# CITY OF ALBUQUERQUE

July 10, 2023

**Re: Starbucks**  
**1440 Coors Blvd. NW**  
**30-Day Temporary Certificate of Occupancy**  
**Transportation Development Final Inspection**  
Architect's Stamp dated 9-14-22 (J11D017)  
Certification dated 6-16-23

SHEET TITLE
**ARCHITECTURAL
SITE PLAN FOR
TRAFFIC CIRCULATION
LAYOUT**

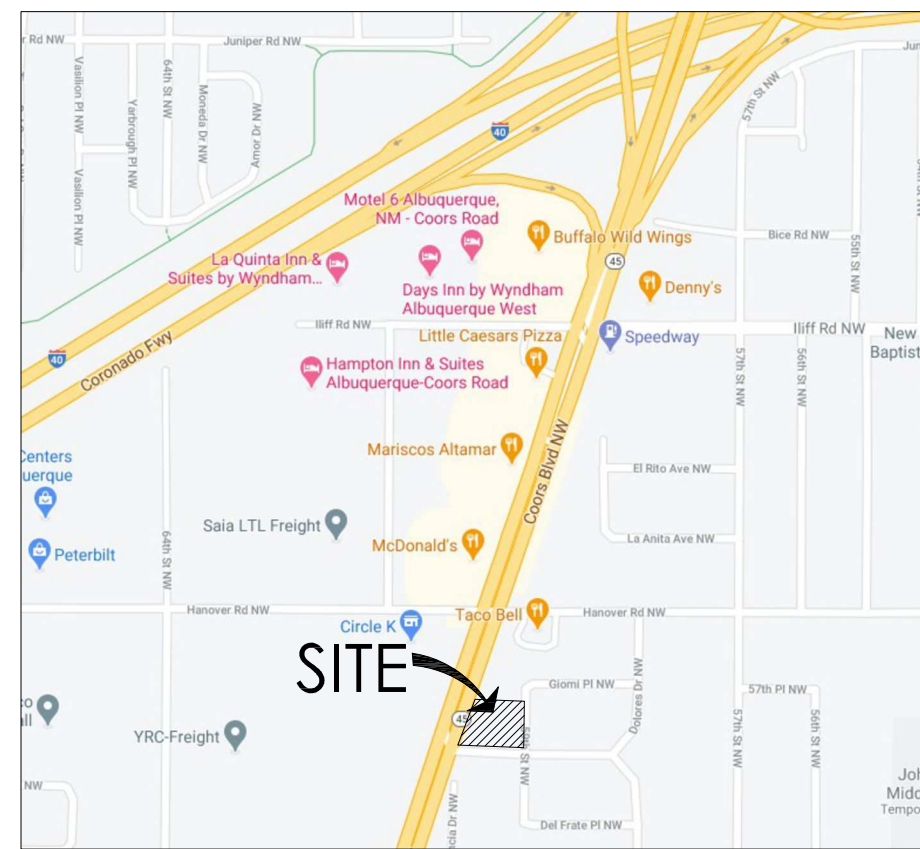
- There was a large shipping container blocking the access way for the ADA parking so I was unable to verify the NO PARKING at the rear of the access way.
- Per the approved plan, the "ONE WAY ONLY" pavement marking at the entrance to the drive-thru and the "DO NOT ENTER" pavement marking at the drive-thru exit were not in place.

Once these corrections are complete, email pictures to [earmijo@cabq.gov](mailto:earmijo@cabq.gov) for release of Final CO.
